TfNSW Reference: SYD21/00232/06

DPIE Reference: SSD-15221509

**EXHIBITION OF EIS - WOOLWORTHS WAREHOUSE & DISTRIBUTION CENTRE
250 VICTORIA STREET, WETHERILL PARK**

Attachment A

26.0m B-DOUBLE VEHICLE
SWEPT PATHS

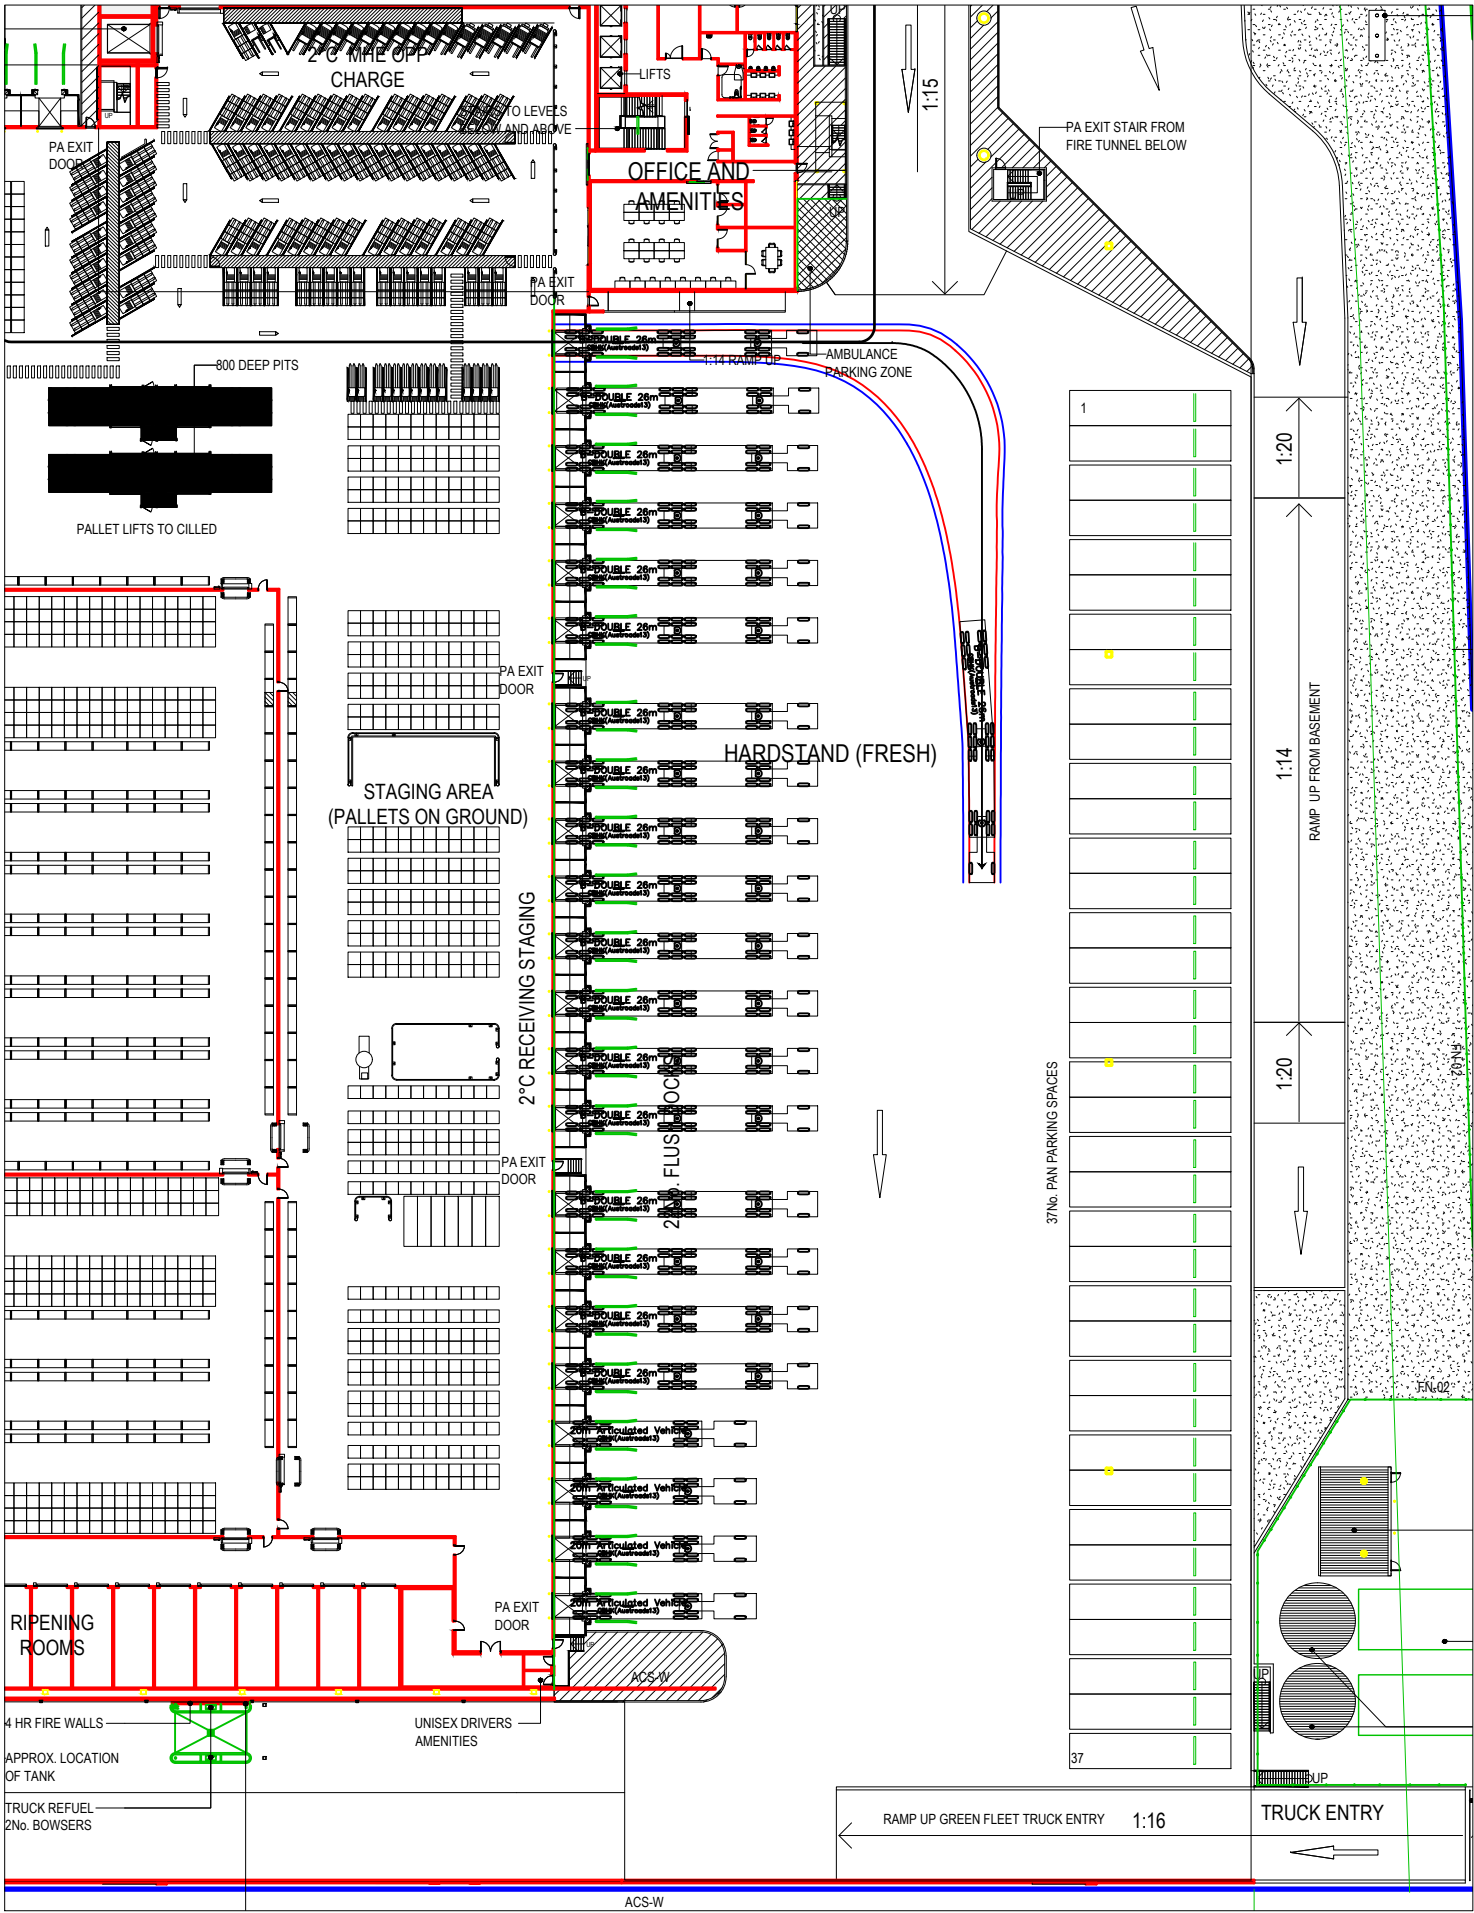
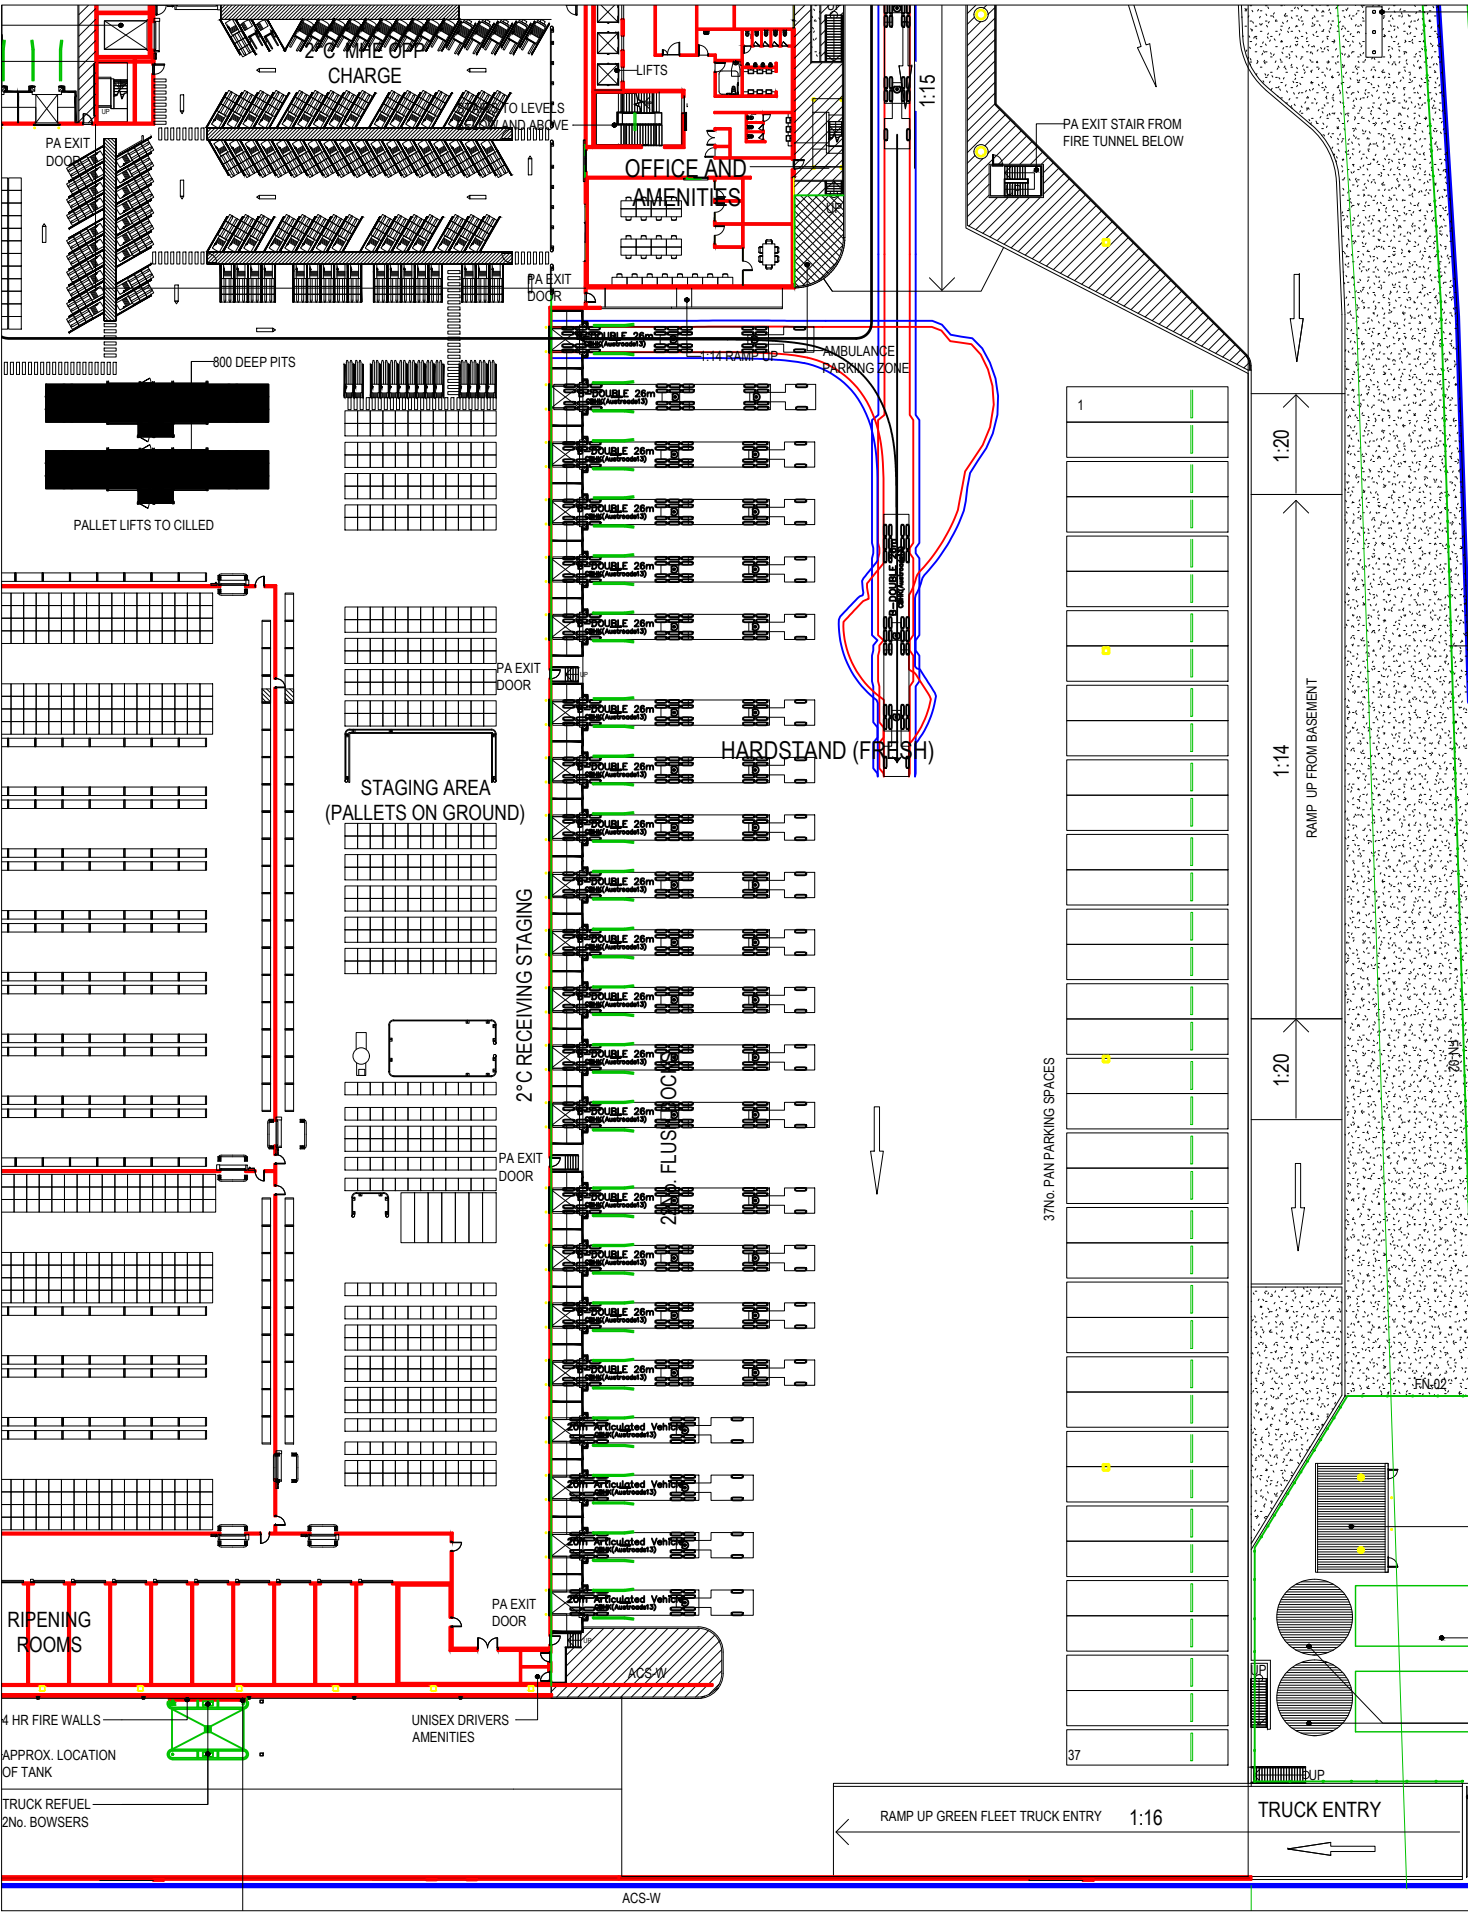
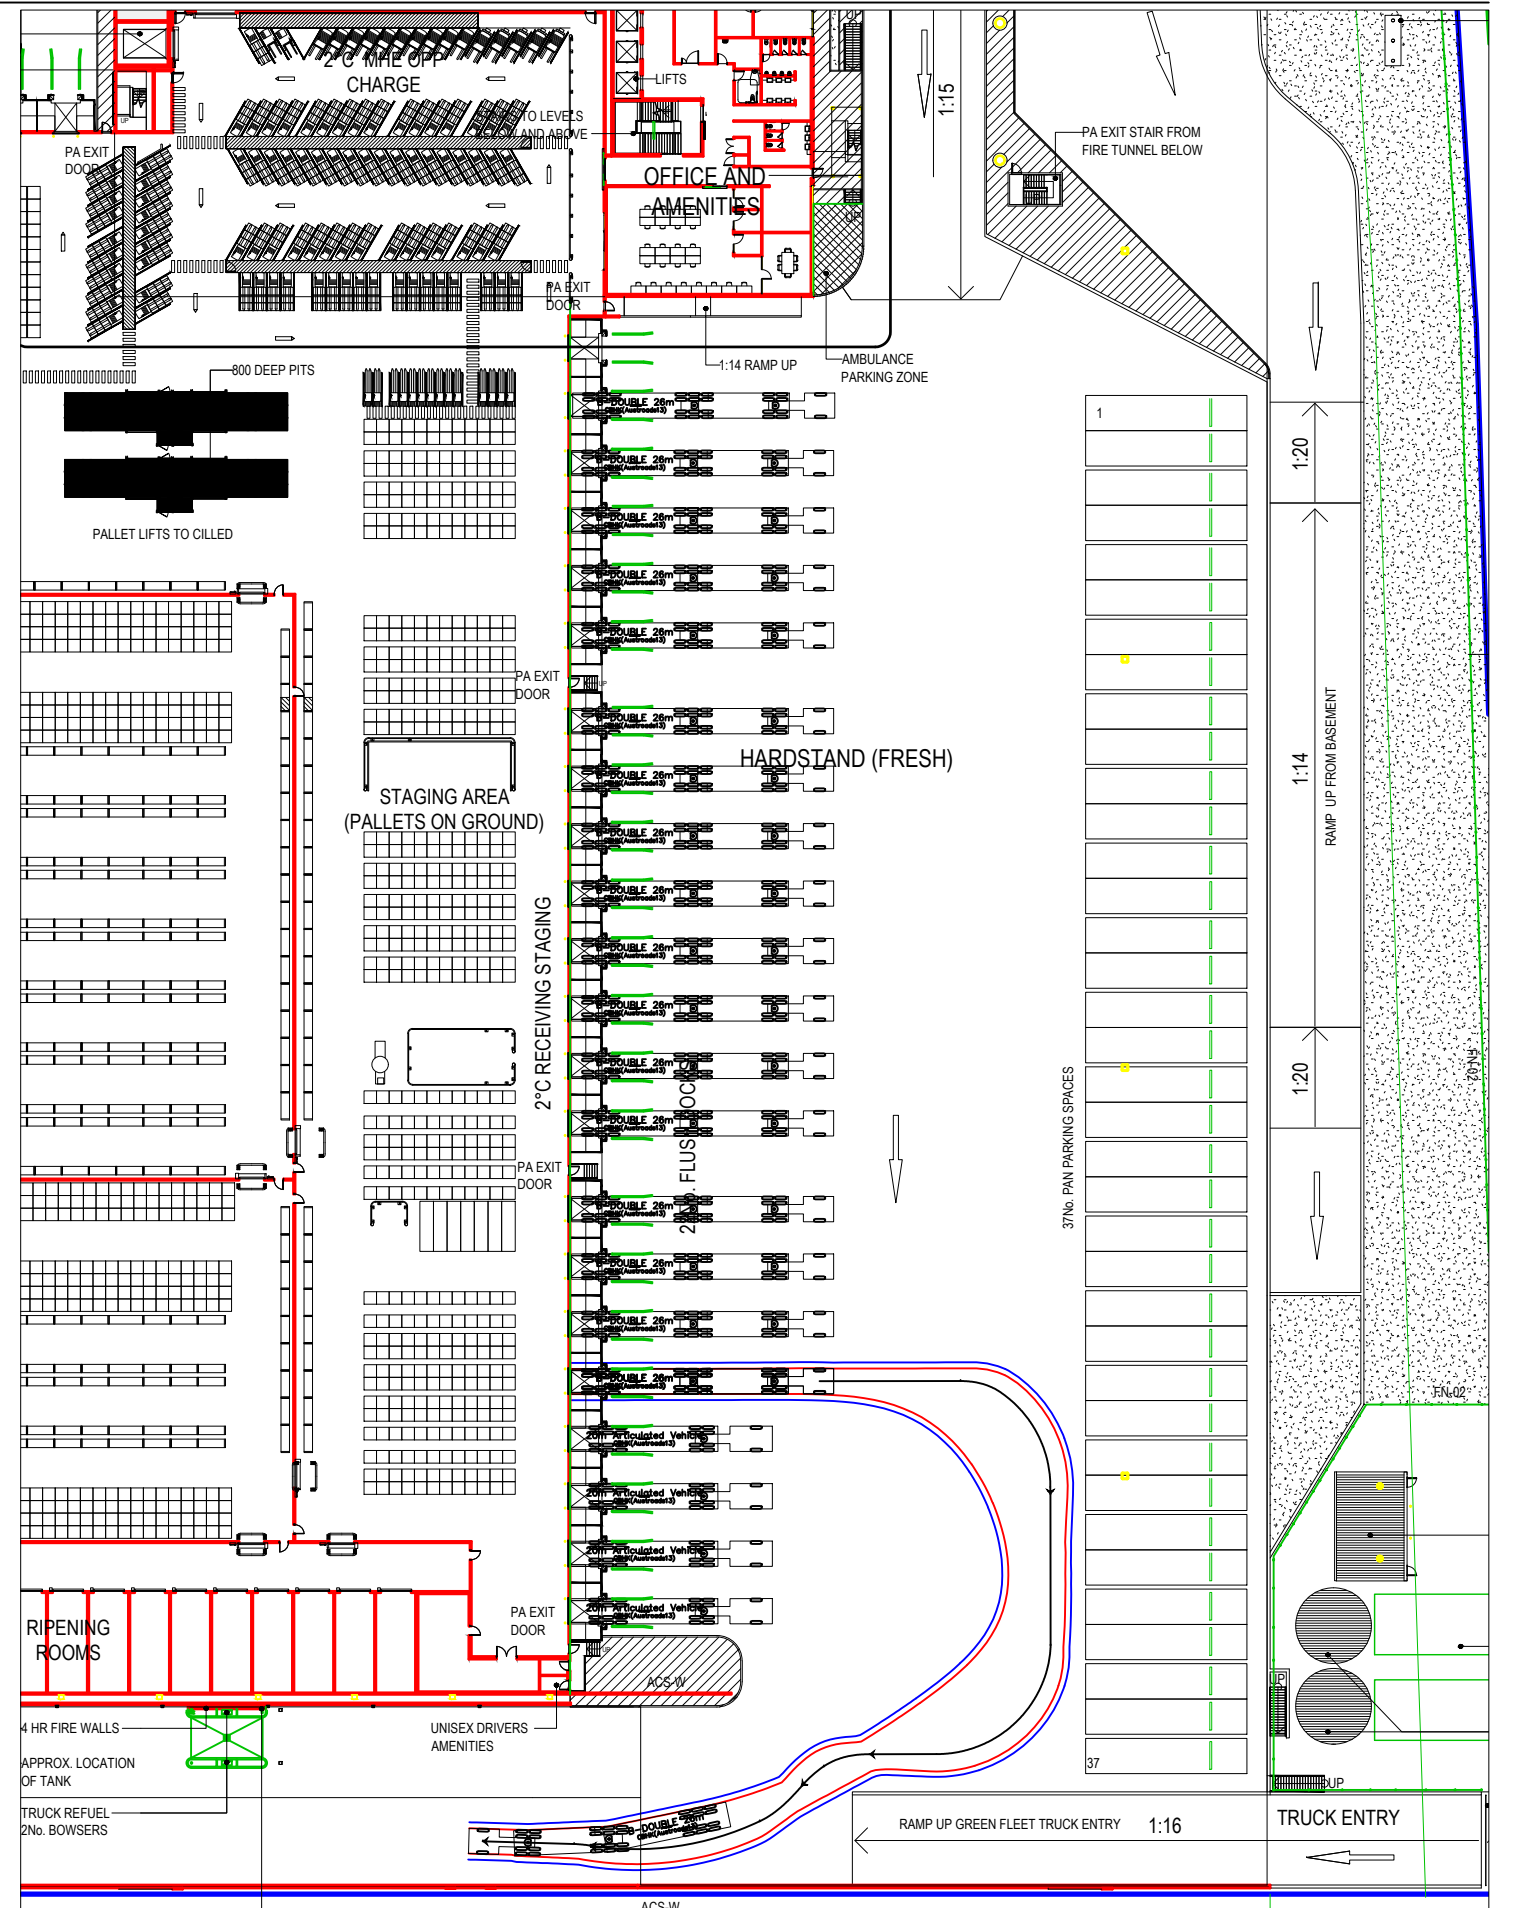
Swept path analysis should be provided for the longest vehicle accessing the site from Victoria Street and demonstrate how simultaneous entry/exit can be achieved at the proposed access.

- Confirmation whether the anticipated number of truck movements generated by the proposal made any assumptions on the use of Higher Mass Limit (HML) vehicles. Both Redfern and Walter Streets are currently not approved for HML short combination nor HML B-Double access.
- Confirmation whether there are any proposed boom gates or access gates for heavy vehicles entering the site as this could potentially cause queuing of heavy vehicles onto Redfern Street.
- Confirmation whether B-double decoupling areas are needed so that both the 'A' and 'B' trailers can be unloaded from the rear. The swept path diagrams show the full B-double combination approaching and departing the loading docks.
